Re: Koneru Short Plat (SUB 21-008/CAO 22-003)
6610 East Mercer Way
Mercer Island, Washington

This revised letter combines our comments for SUB21-003 and CAO22-003 and supersedes our previous letters dated February 16, 2022 (SUB21-008) and February 23, 2022 (CAO22-003). This letter is provided to address whether the proposed subdivision complies with the following Mercer Island City Codes (MICC).

Michele Lorilla, P.E.
Geotechnical Peer Reviewer

**SHEET C0.1**

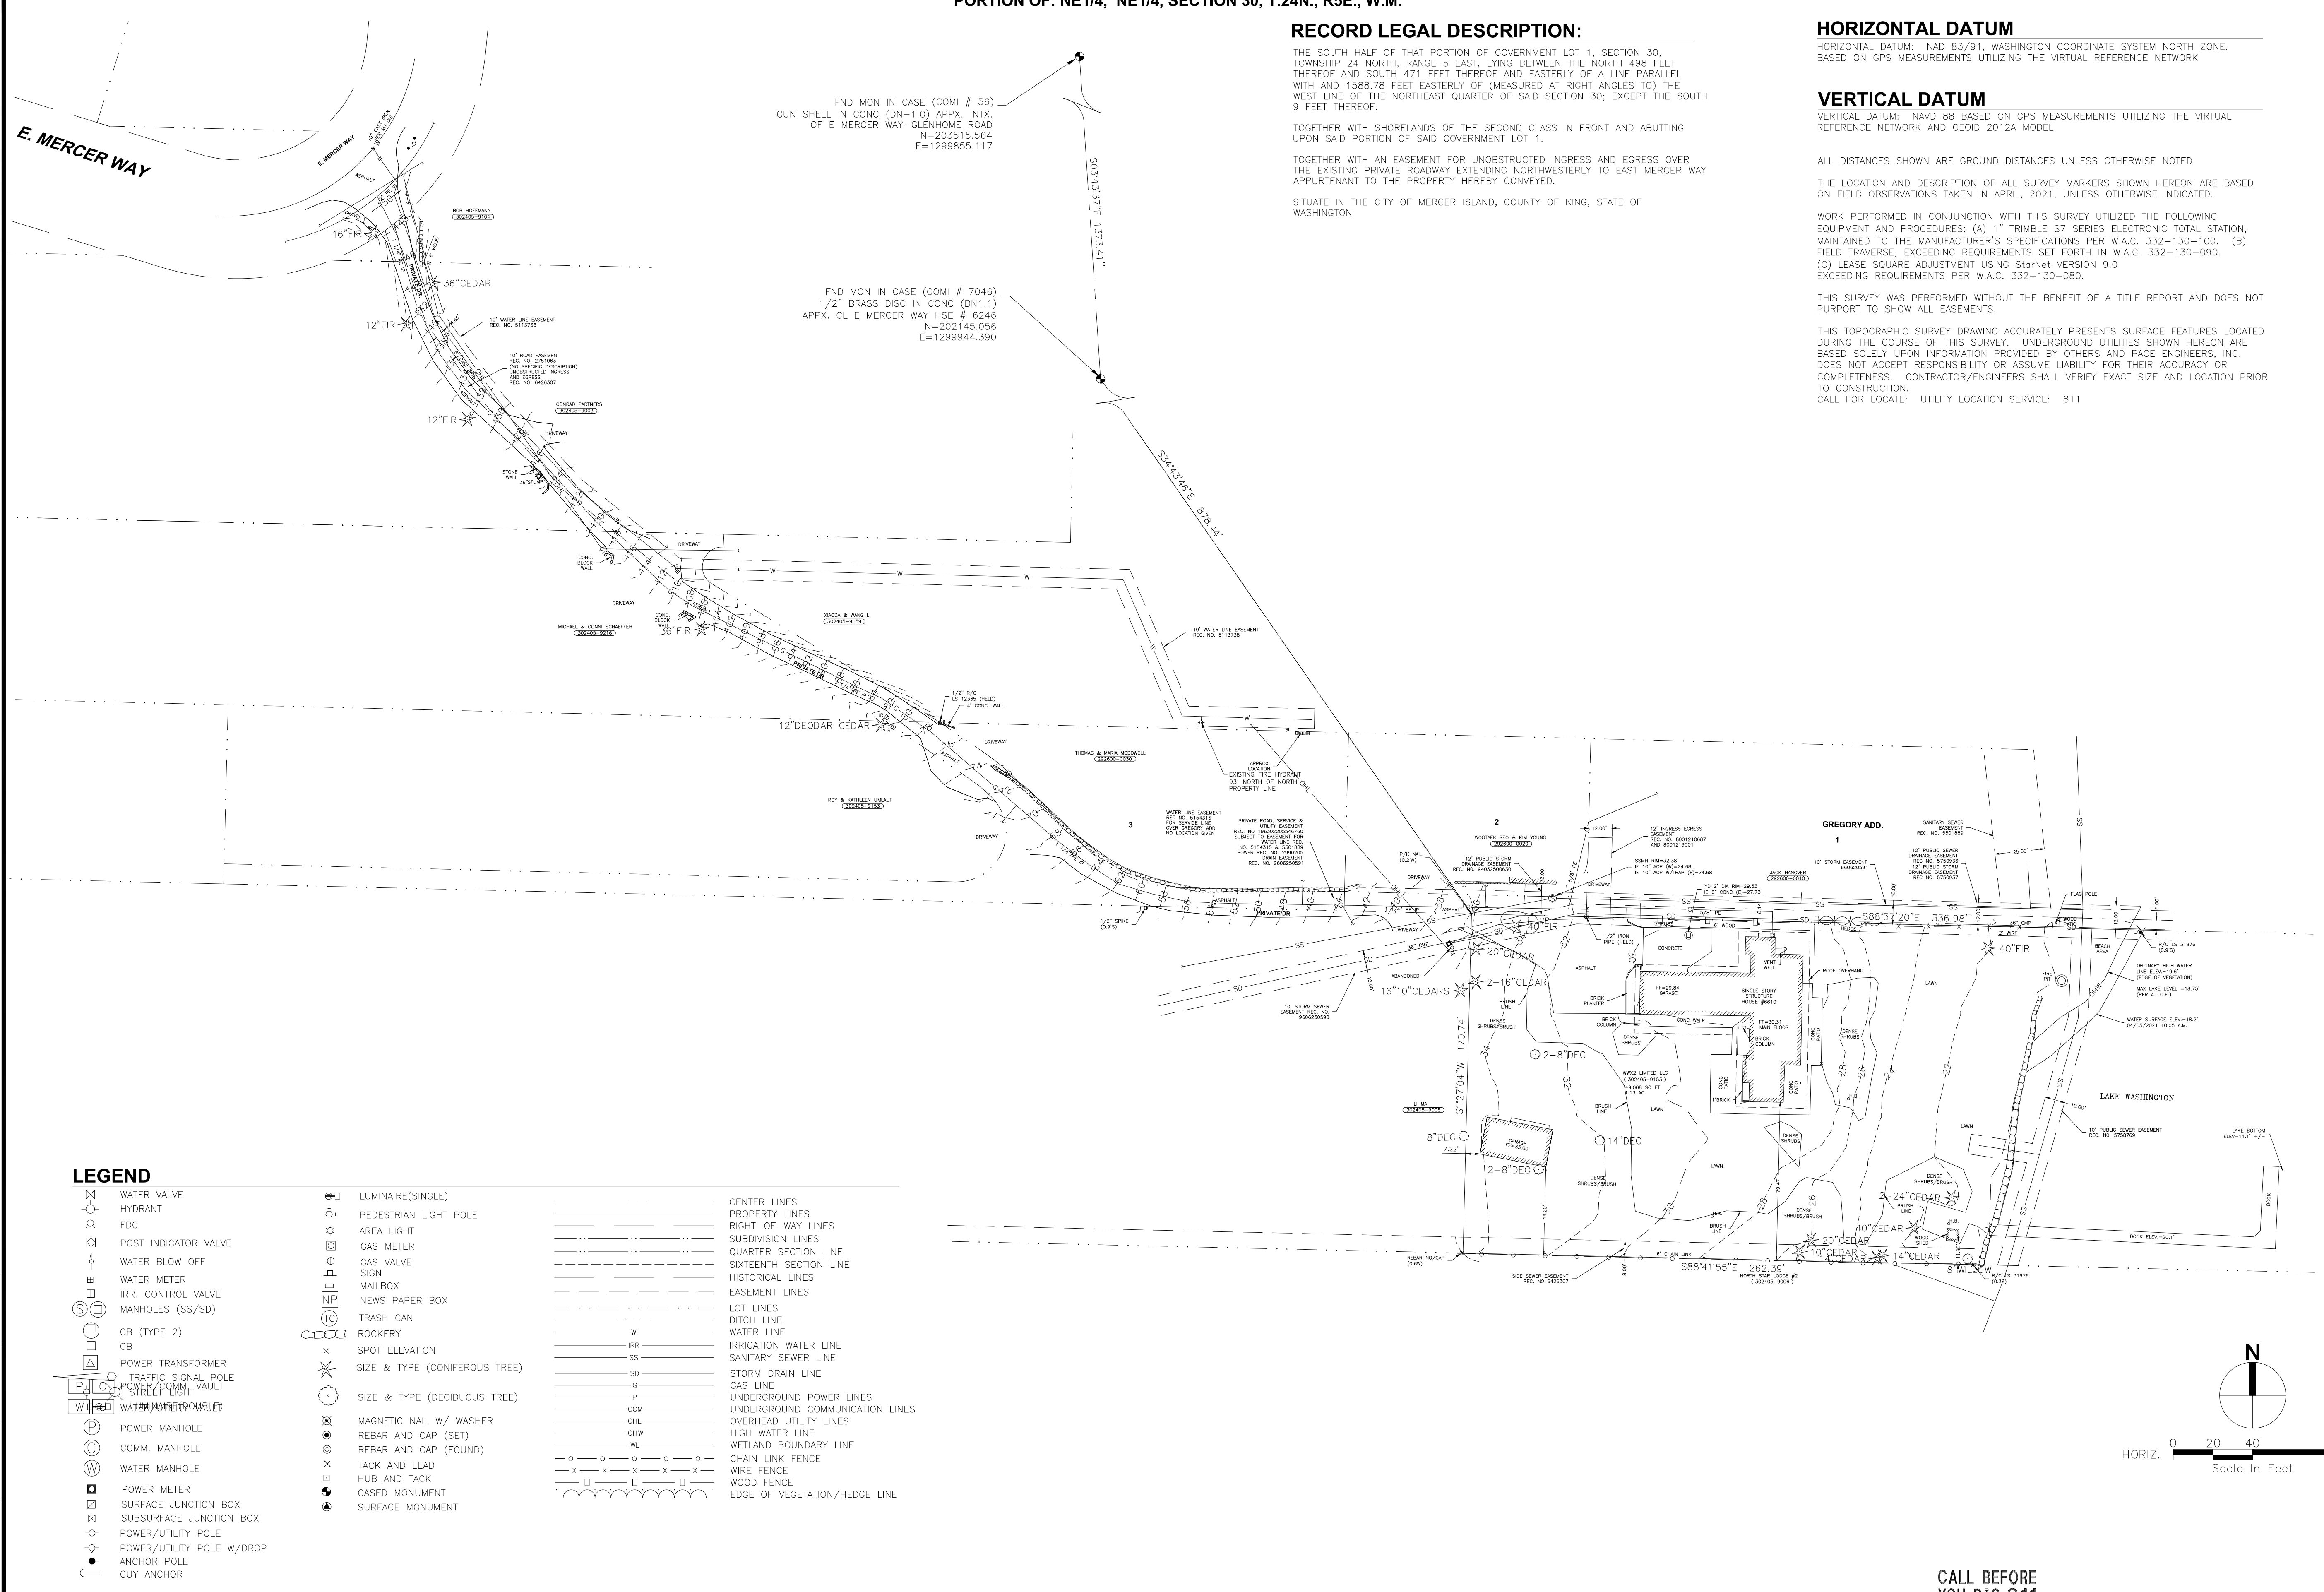
Therefore, we agree with the statement on the cover sheet of the plans. ***“This request does not guarantee that the lots will be suitable for development now or in the future.”***
